**Bradley Villa Farm, Huddersfield
Proposed Residential Development
Transport Assessment Addendum**

October 2021 (Initial Issue)

Prepared on behalf of
Redrow Homes (Yorkshire) Ltd, R Kershaw & S Gill

2021/62/92086/W – Erection of 270 residential dwellings and associated infrastructure and access

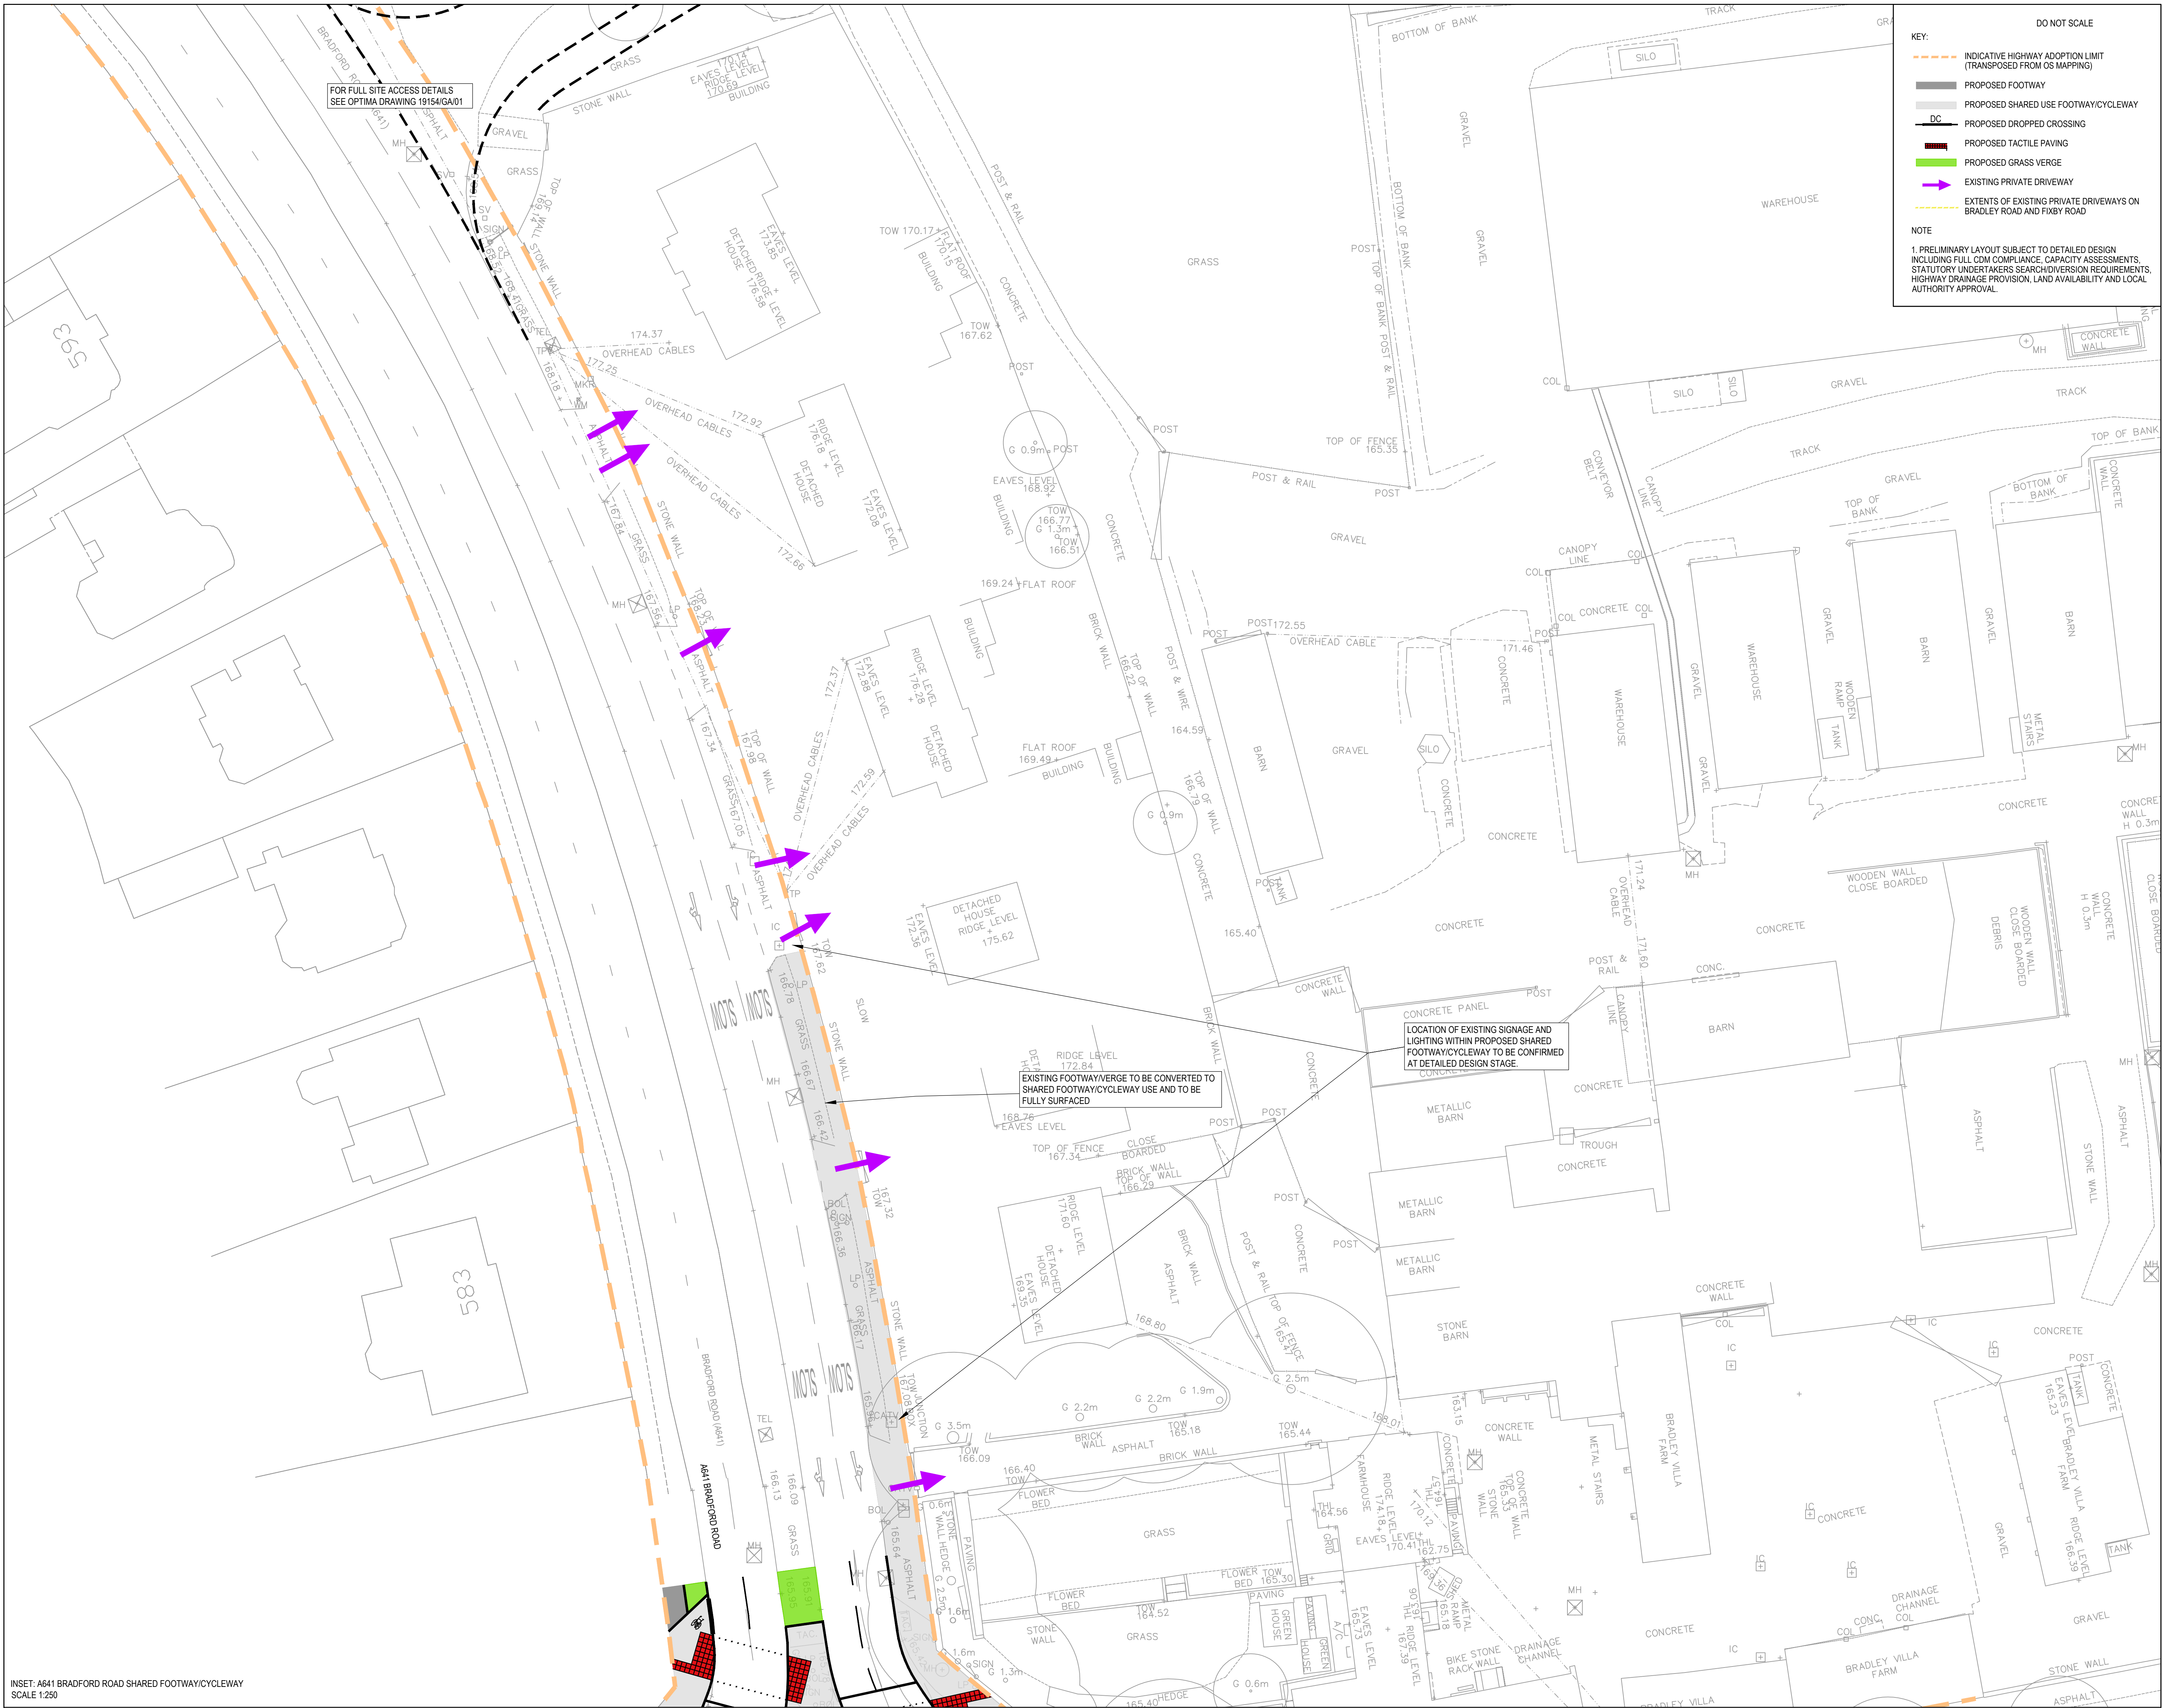
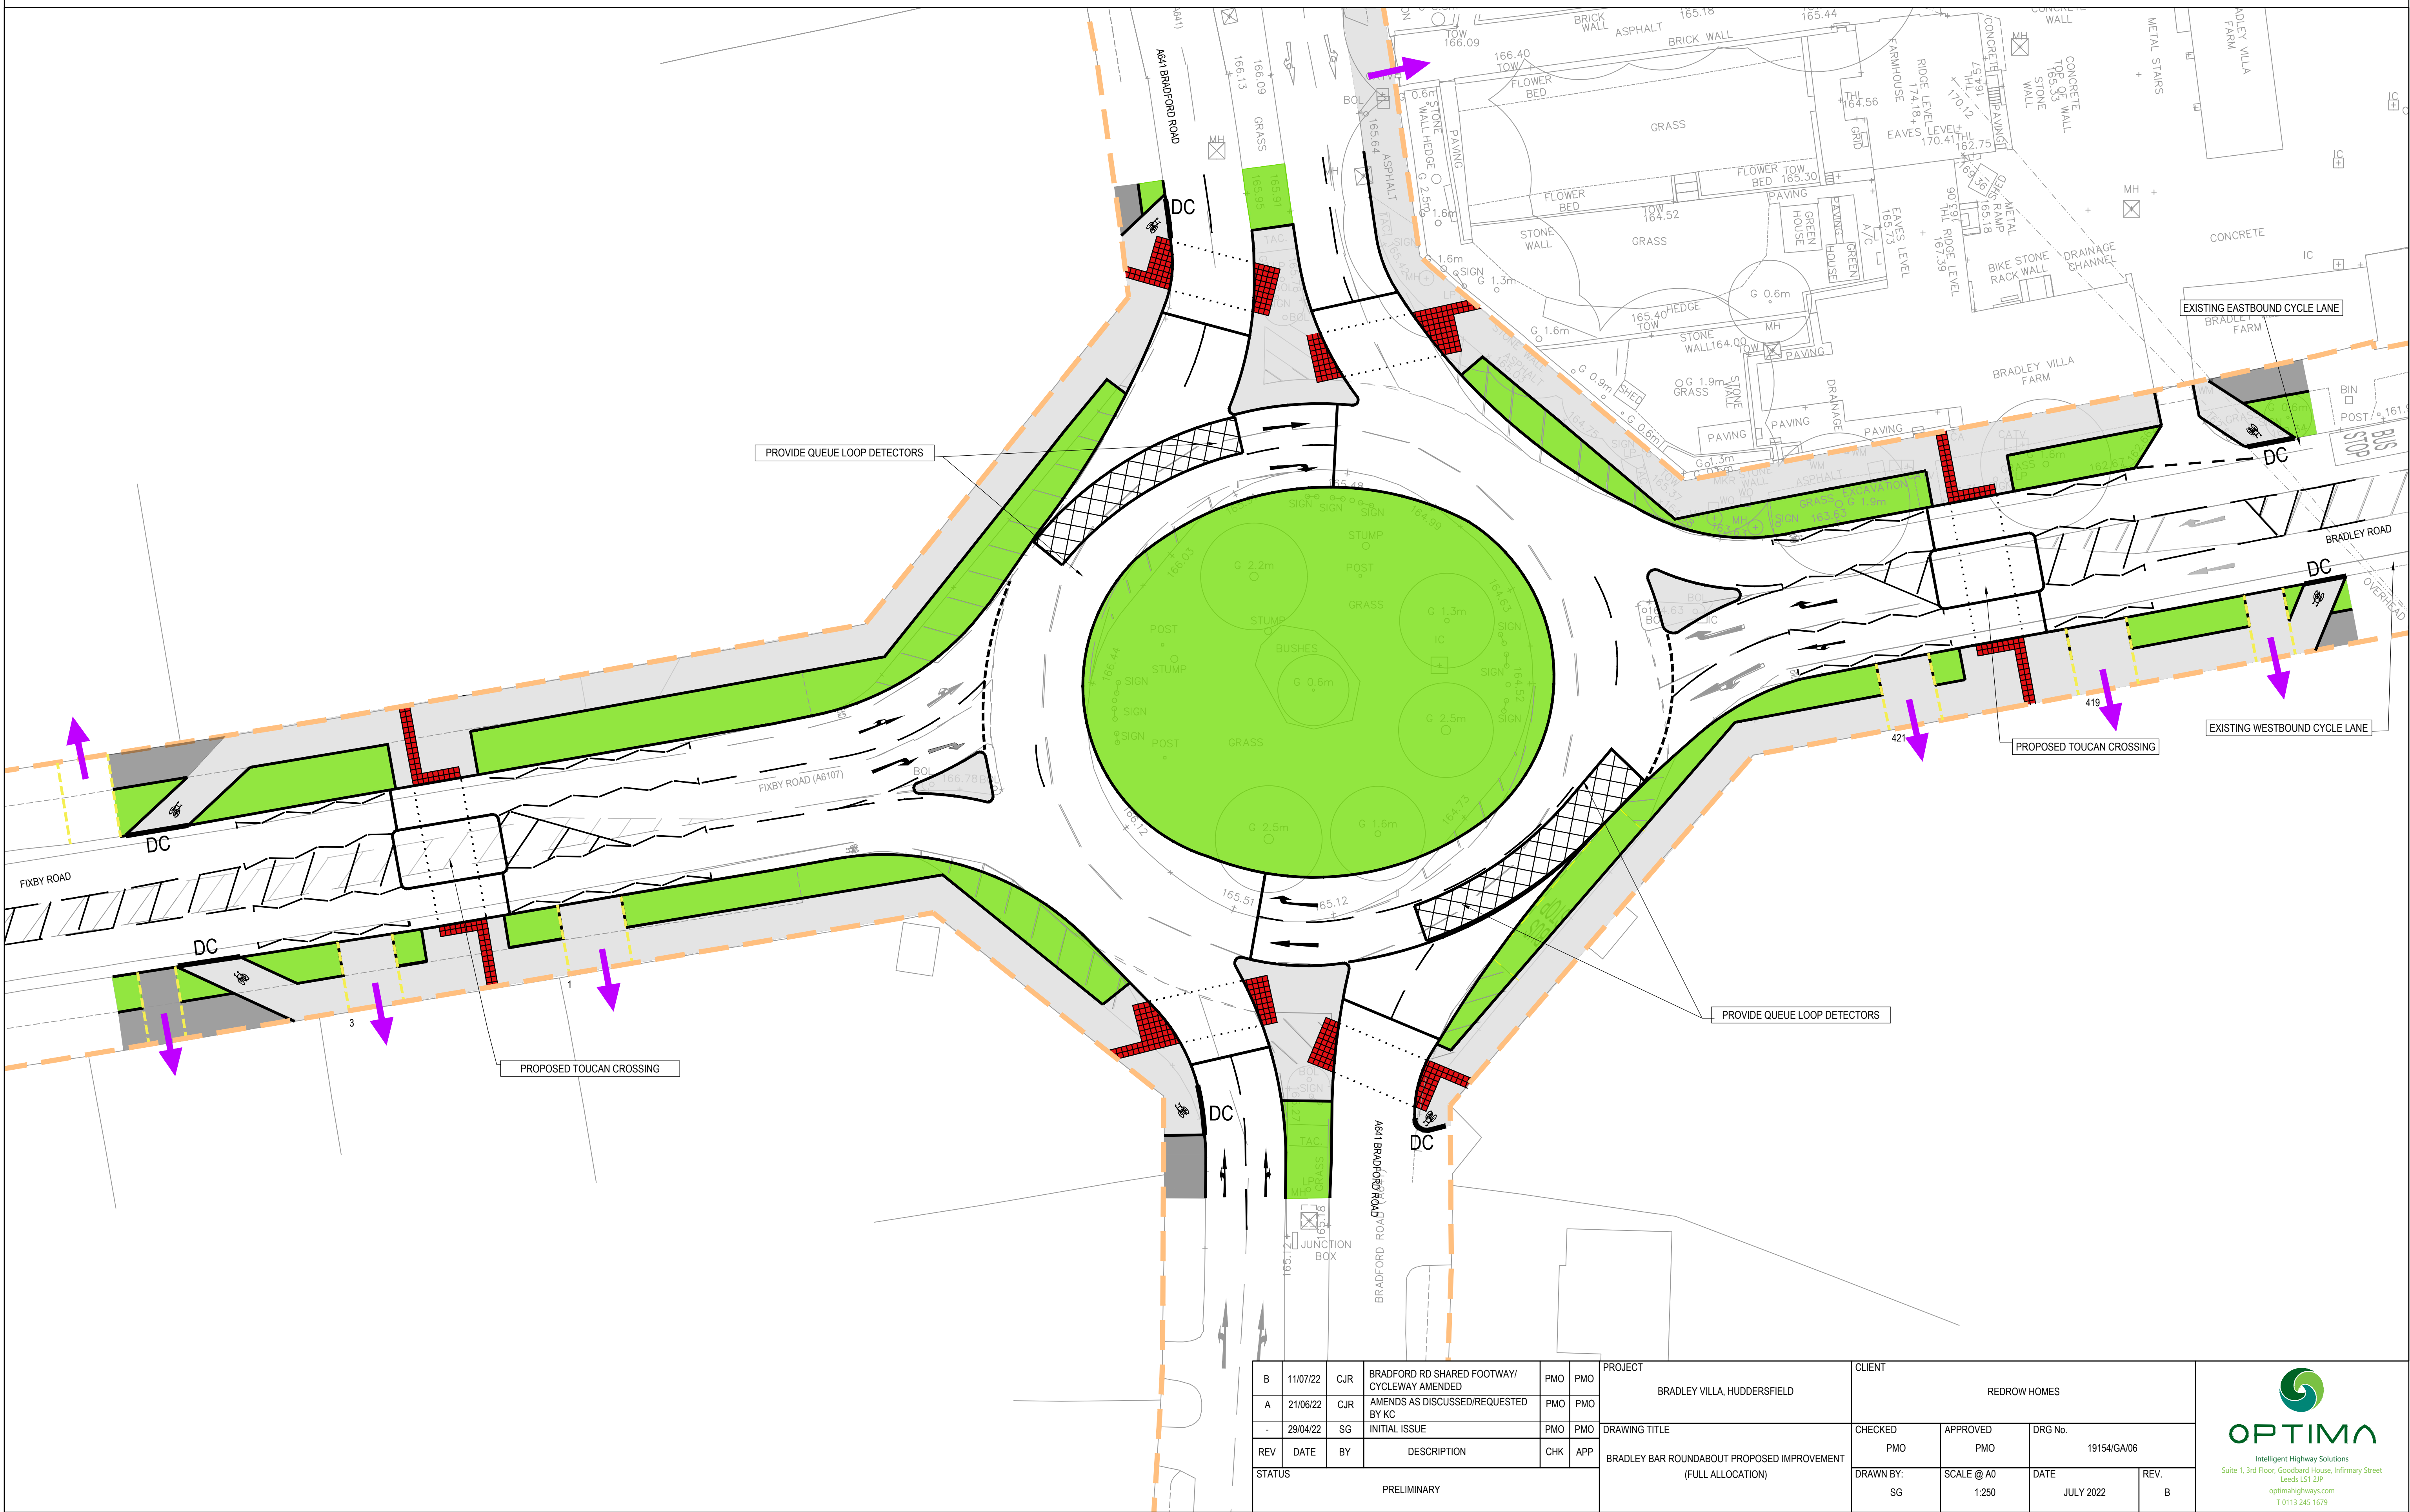
2.2.2 In order for residents of the development Site to satisfactorily access both existing bus stops on Bradford Road the original layout included a staggered, uncontrolled pedestrian crossing (comprising dropped kerbing and tactile paving) between the Site Access and Dorchester Road. In their consultation response the Council raise concerns regarding the provision of an uncontrolled facility and request that *“the application team explores the provision of a signal-controlled pedestrian crossing at a suitable location that facilitates a pedestrian desire line between the site access and the north-bound Bradford Road bus stop”*.

It is proposed to take vehicular access via an existing opening off the eastern side of the A641 Bradford Road via a new junction incorporating a right-turn ghost lane to facilitate right-turn vehicular manoeuvres into the site (not possible at present due to the central reserve). In accordance with the broader Masterplan, there is a vehicular connection proposed to the wider HS11 site, to the east of this development site. Through the site, a new primary road corridor (spine road) would be created, forming a 6.75m wide carriageway with a 3m cycleway along the northern edge and a 2m wide footway to the south.

- 6.75m carriageway on Site Access;
- 2.0m footway to southern side of the Site Access;
- 3.0m shared footway/cycleway to northern side of the Site Access;
- Pedestrian crossing facilities on the Site Access comprising a central refuge island, dropped crossings and tactile paving;
- Pedestrian facilities across Bradford Road comprising staggered dropped crossings and tactile paving;
- 3.0m right turning lane on Bradford Road;
- 6.7m to 6.5m northbound and southbound through lanes on Bradford Road; and
- 2.4 x 120m visibility splays in accordance with the 40mph speed limit.

This should be subject to a full Road Safety Audit (Stages 1-4) and would form a future Section 278 Application/Agreement for off-site highways works. The submitted drawing should be secured by an appropriate planning condition, as should the Stage 1-4 Road Safety Audit. This is discussed in more detail, later.

2.2.3 Such a scheme has therefore been explored/designed and a staggered signalised pedestrian crossing is proposed to be provided on Bradford Road between the Site Access and Dorchester Road – as shown on the drawing in Appendix C and the extract in Image 2.1. The location of the crossing facilitates the pedestrian desire line between the northbound bus stop and the Site Access as well as ensuring there is satisfactory visibility of the signalised stoplines for vehicles emerging from Dorchester Road as well as for vehicles travelling northbound and southbound along Bradford Road.

2.2.5 In their consultation response Kirklees Council state that they require the proposed Bradford Road/Site Access arrangements (as shown on the drawing in Appendix C) to be secured by a suitable planning condition, alongside a further planning condition requiring a full Road Safety Audit (Stages 1 to 4) as the layout progresses to detailed design and construction. This is a standard requirement and is acceptable.
